Reference No:	2026/62/91063/E
Site Address:	382, Huddersfield Road, Mirfield, WF14 9DL
Description:	Re-instatement and repair of existing building including alterations to roof and associated works
Recommending Officer:	Nicole Helliwell

Officer Report

Proposal: Re-instatement and repair of existing building including alterations to roof and associated works

Proposed Ground Floor Plan
1 : 50

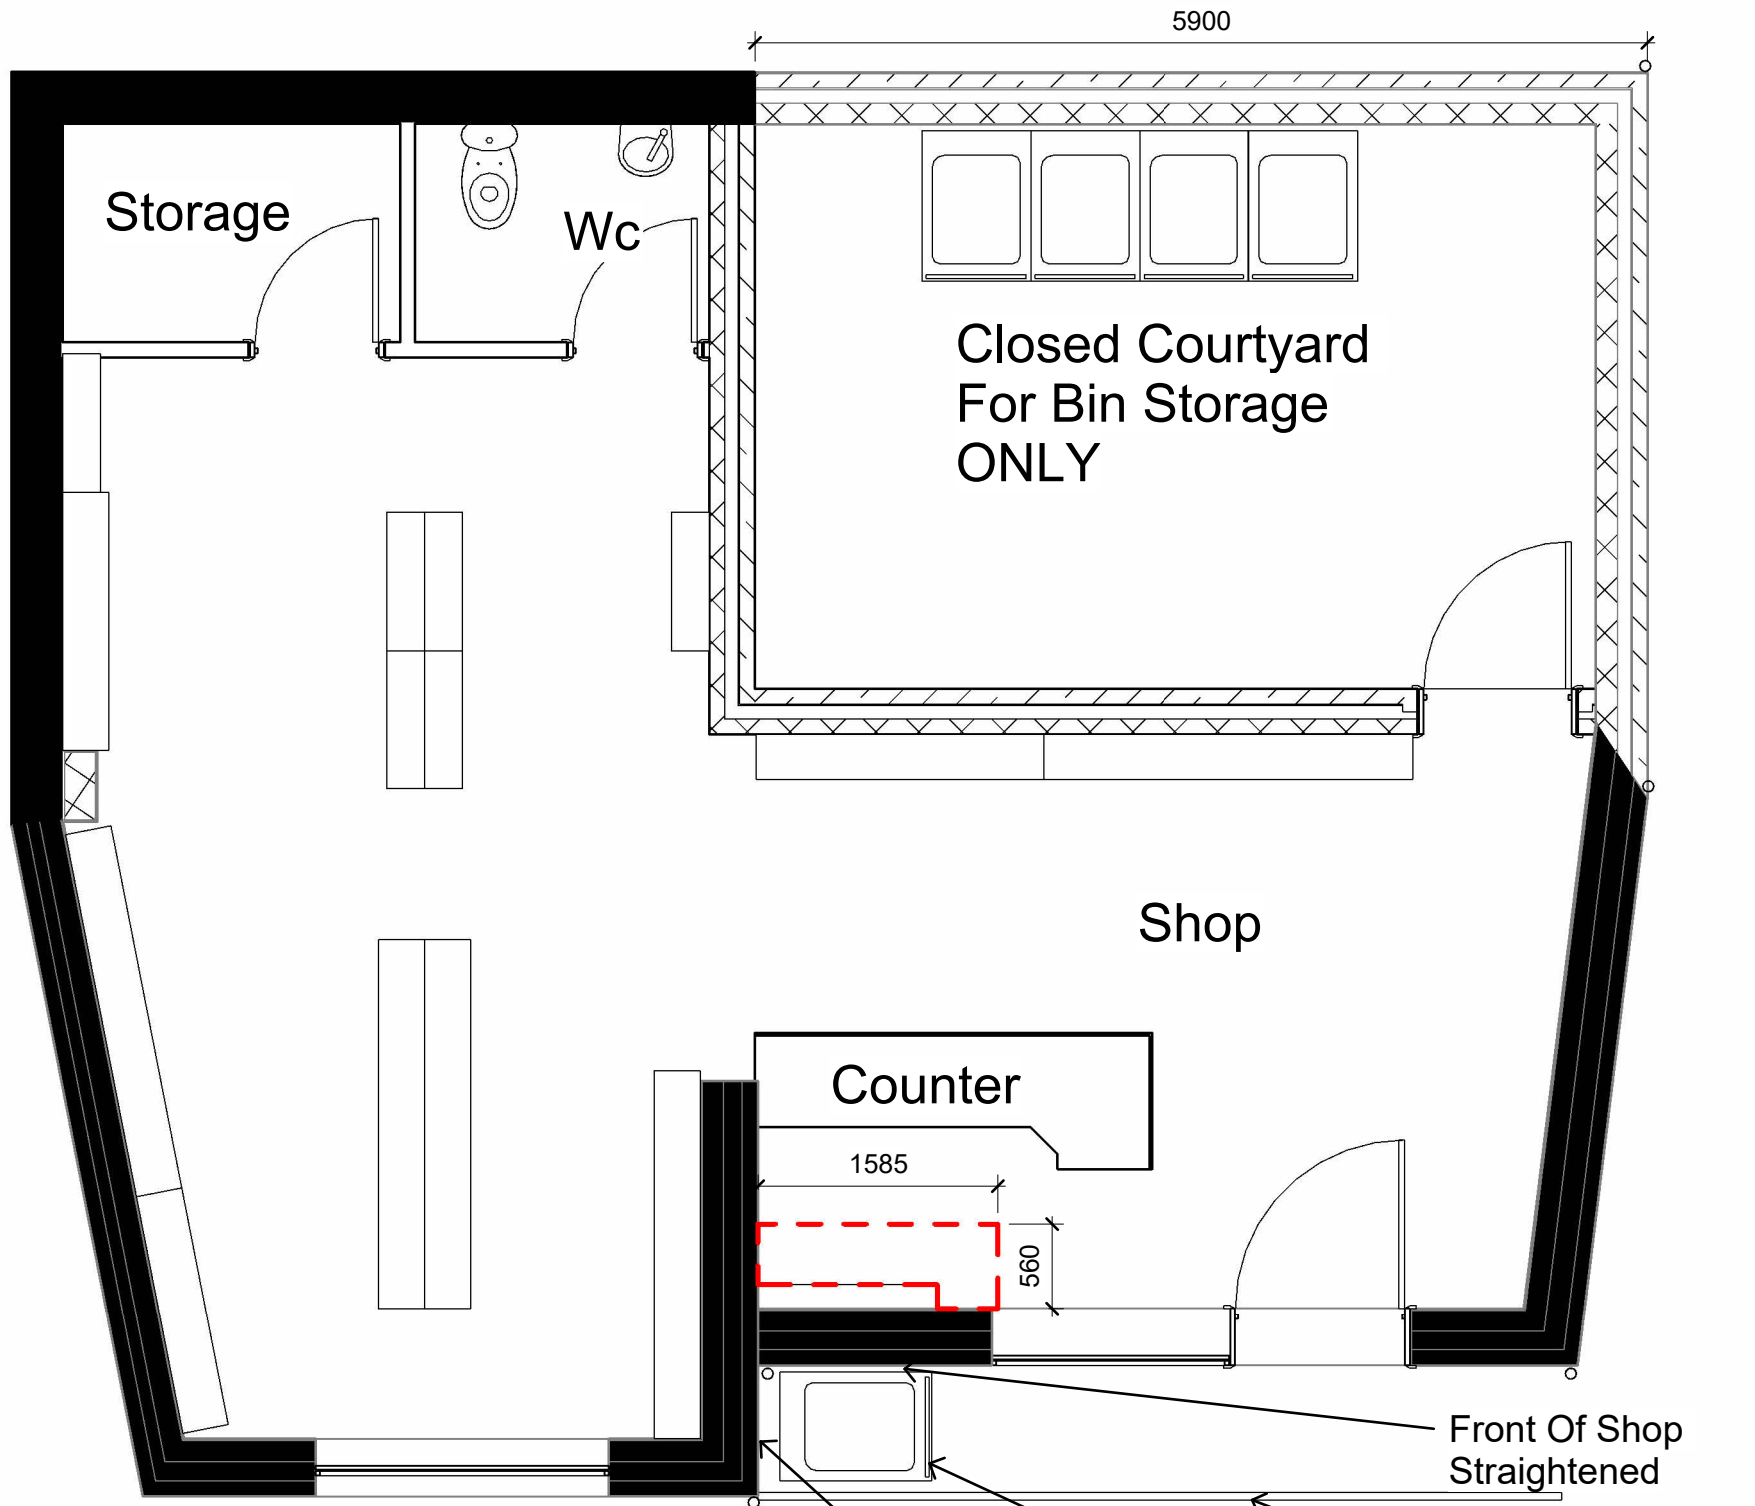
Amendments were sought during the course of the application. A request was made to remove part of the barrier within the frontage of the site so that access can be made via Huddersfield Road and not the public footpath. Revised drawings were received which were considered acceptable in this regard.

KC PROW did raise concerns as to how the building would be accessed and would object to access being taken from the footpath. However, the agent has since clarified that access would be via Huddersfield Road and revised drawings have been submitted to reflect this.

Proposed East South East Elevation (Right)
1 : 50

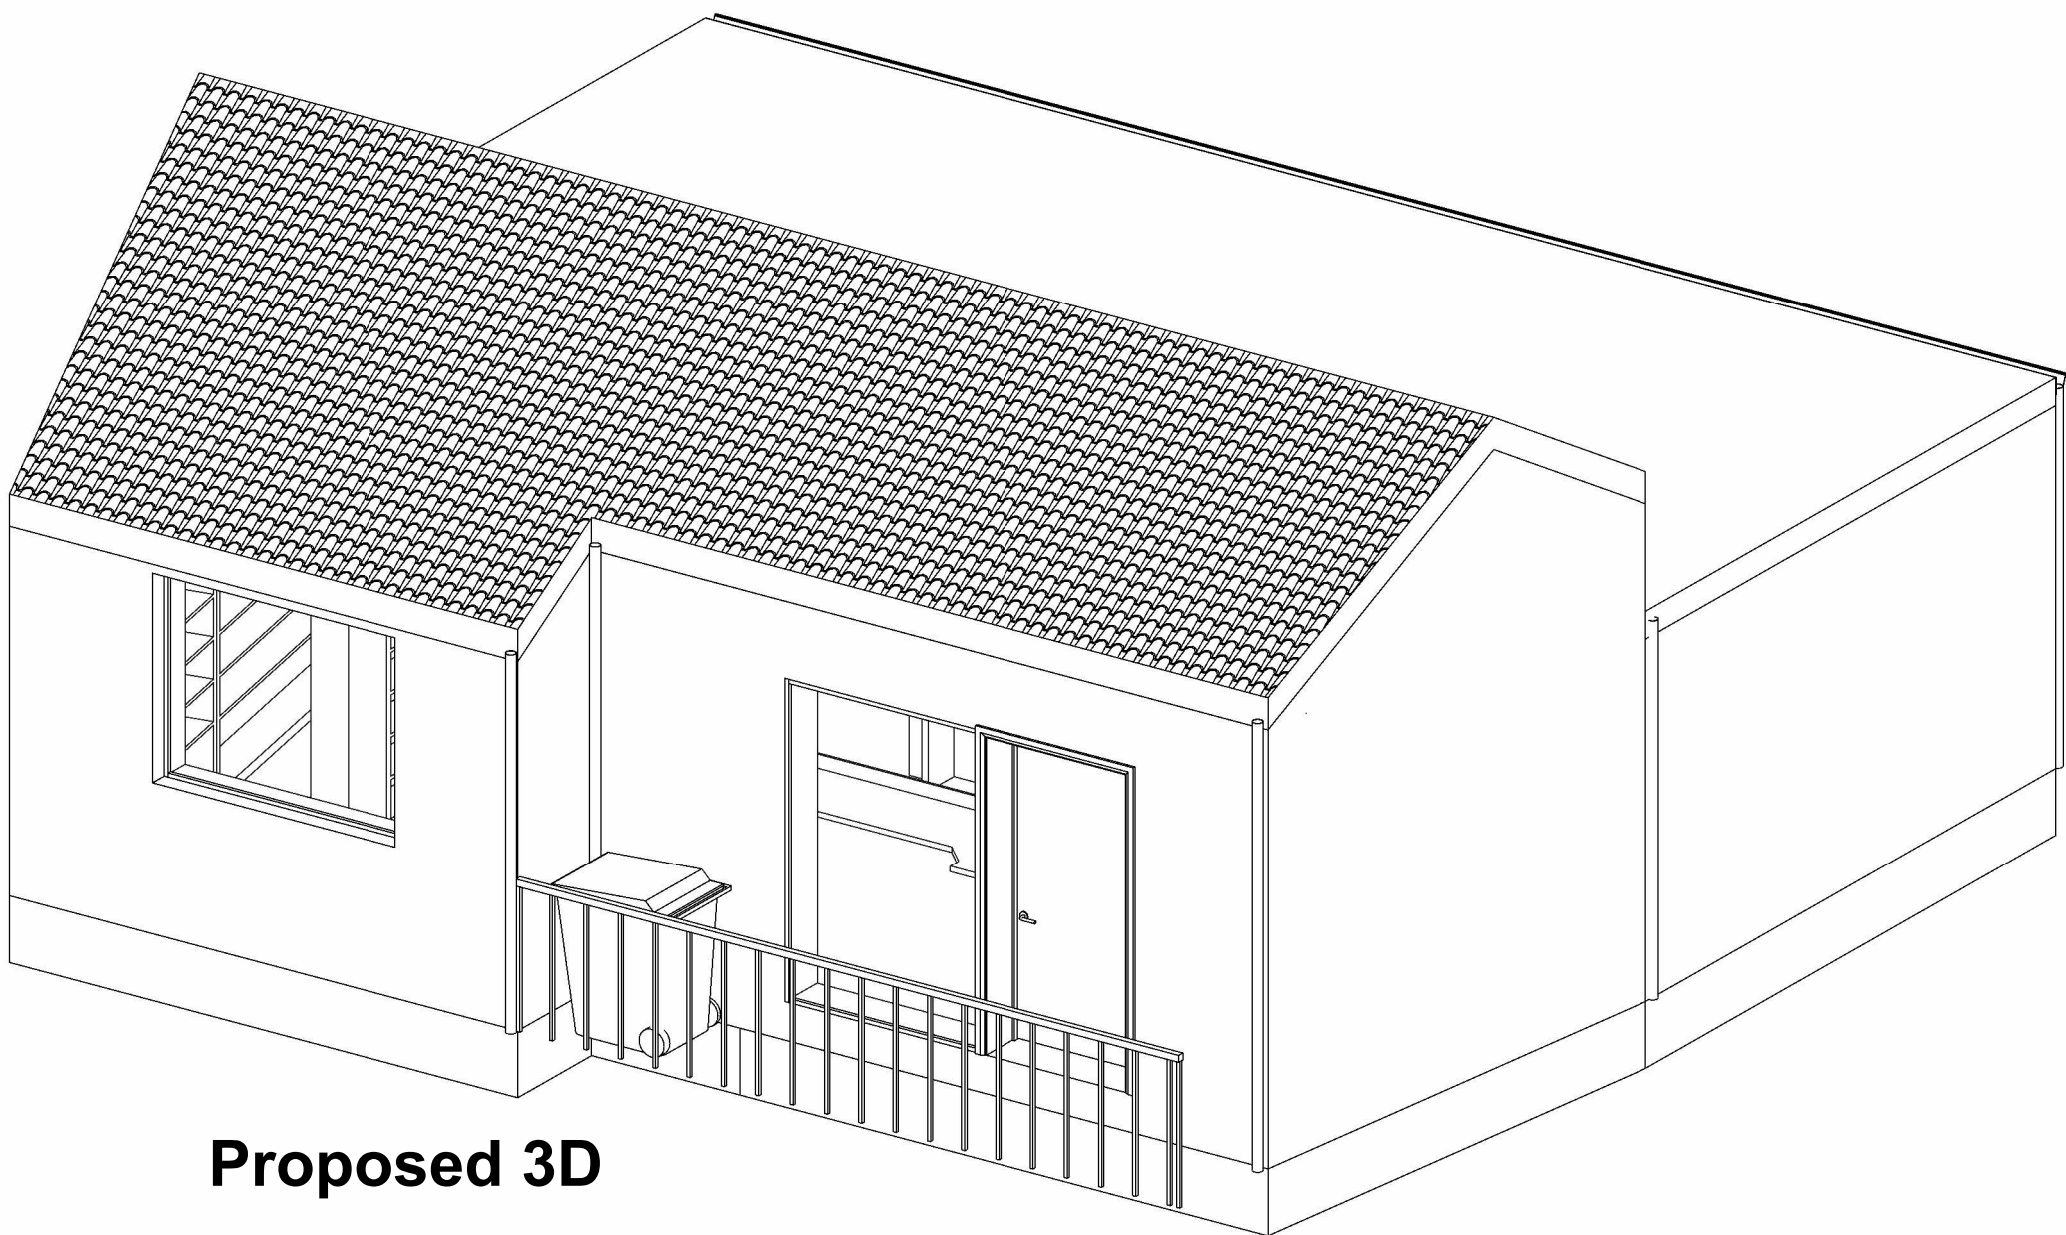
- Materials will be selected to match or compliment the original building particularly through the use of stone faced external walls. The East South East elevation Right gable wall was previously in stone, it has been demolished and built in concrete blocks instead, this is not in keeping with the surrounding area.

- Materials will be selected to match or compliment the original building particularly through the use of stone faced external walls. The East South East elevation Right gable wall was previously in stone, it has been demolished and built in concrete blocks instead, this is not in keeping with the surrounding area.

4. The alterations to the external walls hereby approved shall be faced in stone. Any alterations to the roof shall be finished in tiles. The materials of construction shall be retained thereafter.
